Our Reference: SYD18/00975/03

Department Ref: SSD 9403

**EXHIBITION OF RESIDENTIAL DEVELOPMENT  
1 & 2 MURRAY ROSE AVENUE, SYDNEY OLYMPIC PARK (SSD 9403)**

- Height Clearance:** **2.2m** (min) throughout all areas of the car park accessible to vehicles and bicycles.
2.5m above accessible and shared bays
X wherever access is required for a refuse vehicle (and safety clearance envelope)

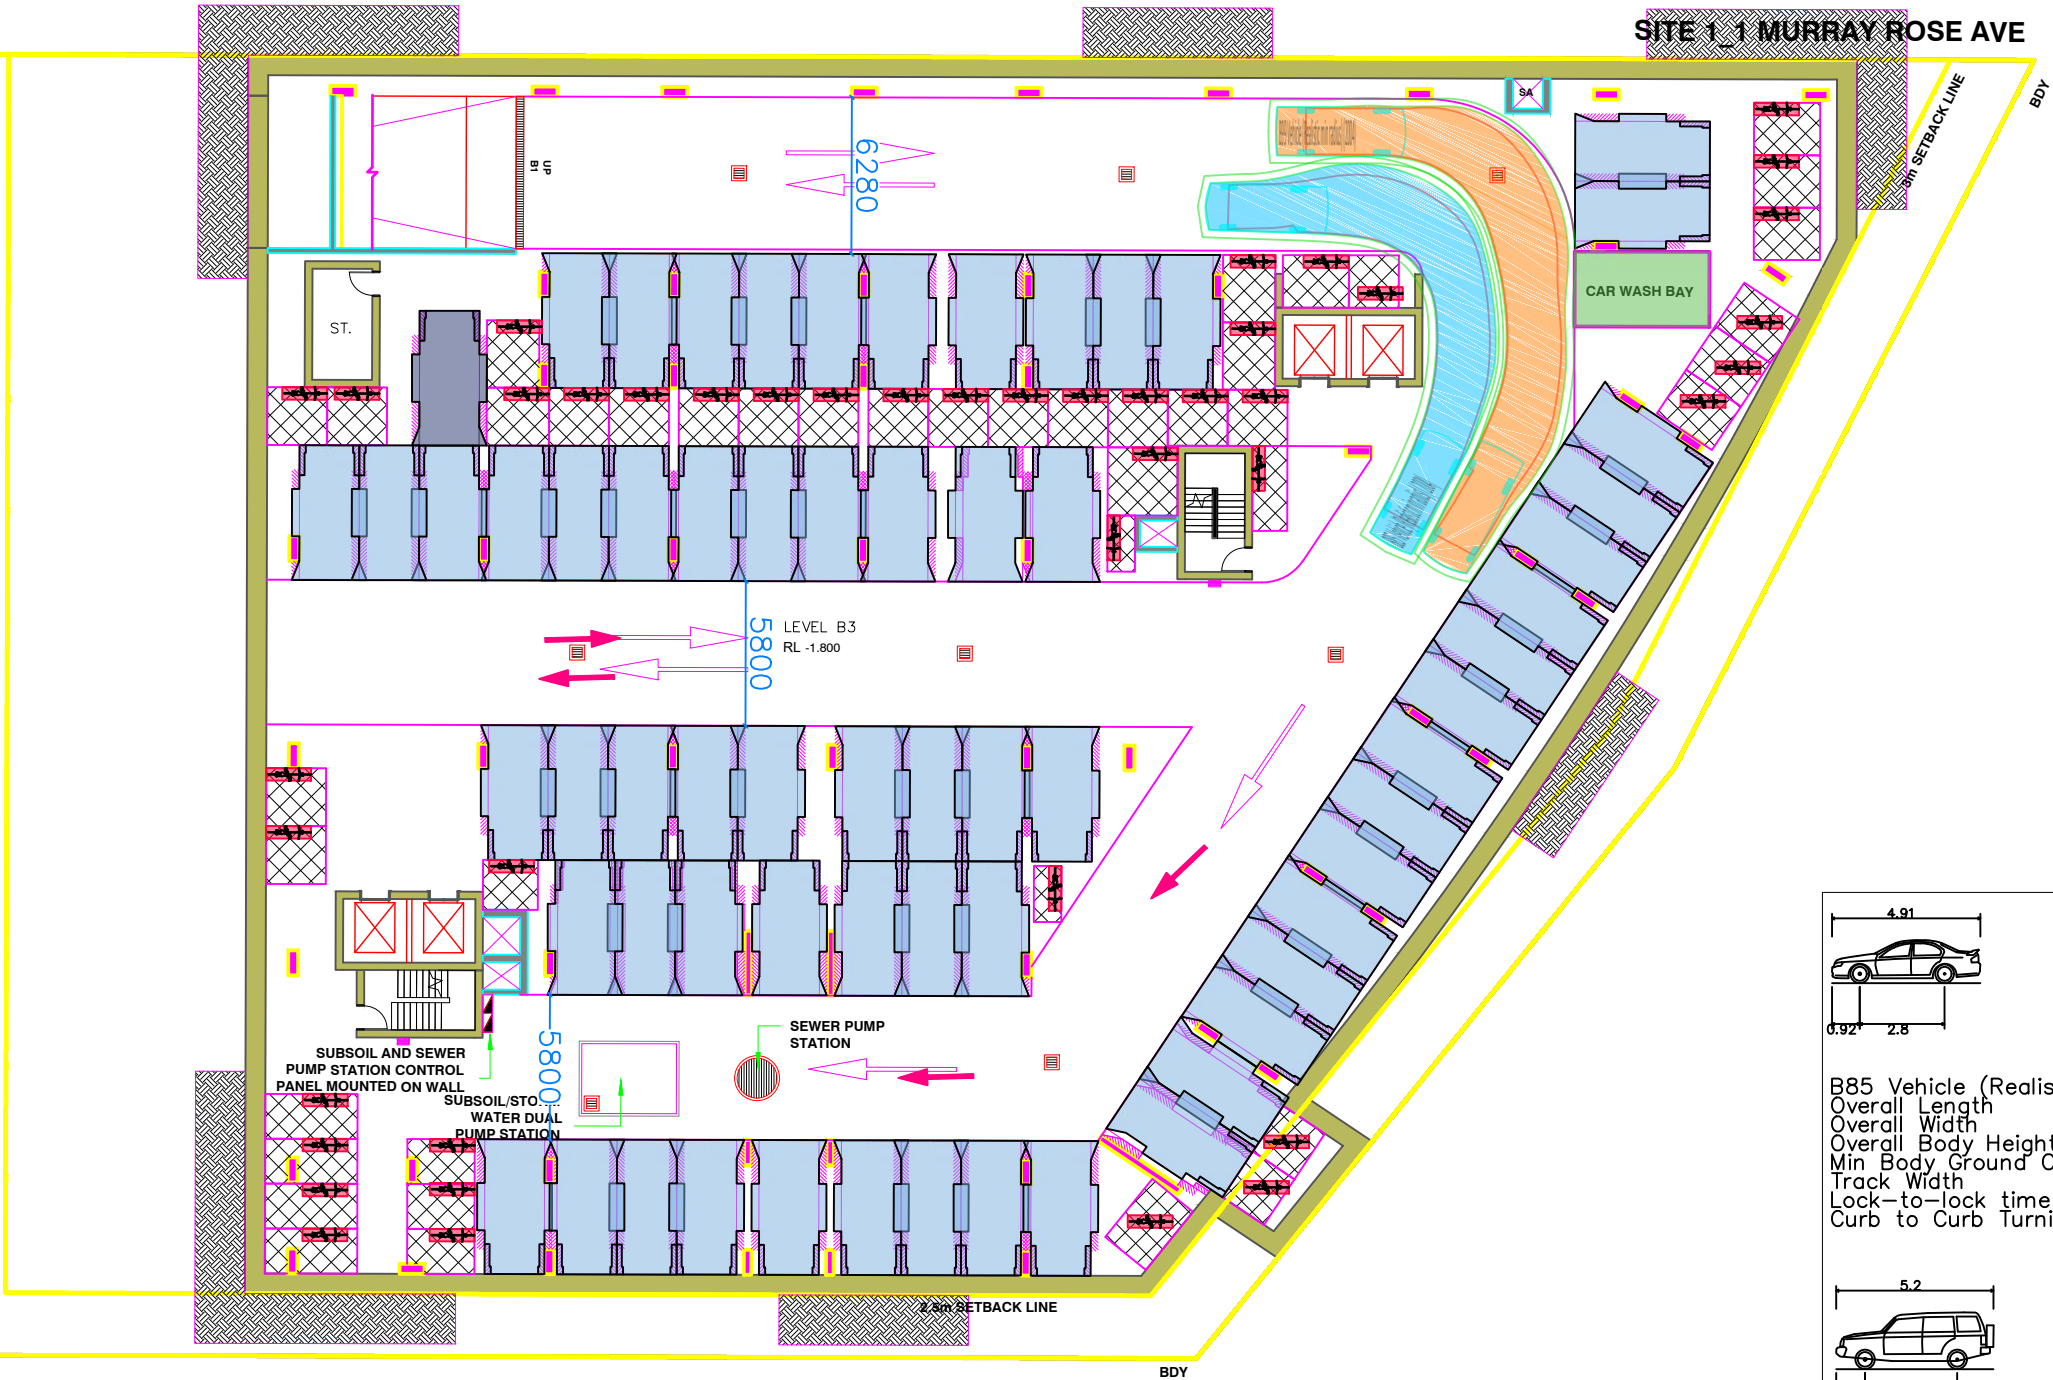
1. The layout of the proposed car parking areas associated with the subject development (including, driveways, grades, turn paths, sight distance requirements in relation to landscaping and/or fencing, aisle widths, aisle lengths, and parking bay dimensions) should be in accordance with AS 2890.1- 2004, AS2890.6-2009 and AS 2890.2 – 2002 for heavy vehicle usage. Parking Restrictions may be required to maintain the required sight distances at the driveway.

2. Bicycle parking should be provided in accordance with AS2890.3.
3. The swept path of the longest vehicle (including garbage trucks, building maintenance vehicles and removalists) entering and exiting the subject site, as well as manoeuvrability through the site, shall be in accordance with AUSTROADS. In this regard, a plan shall be submitted to Council for approval, which shows that the proposed development complies with this requirement.

4. All vehicles are to enter and leave the site in a forward direction.
5. All vehicles are to be wholly contained on site before being required to stop.
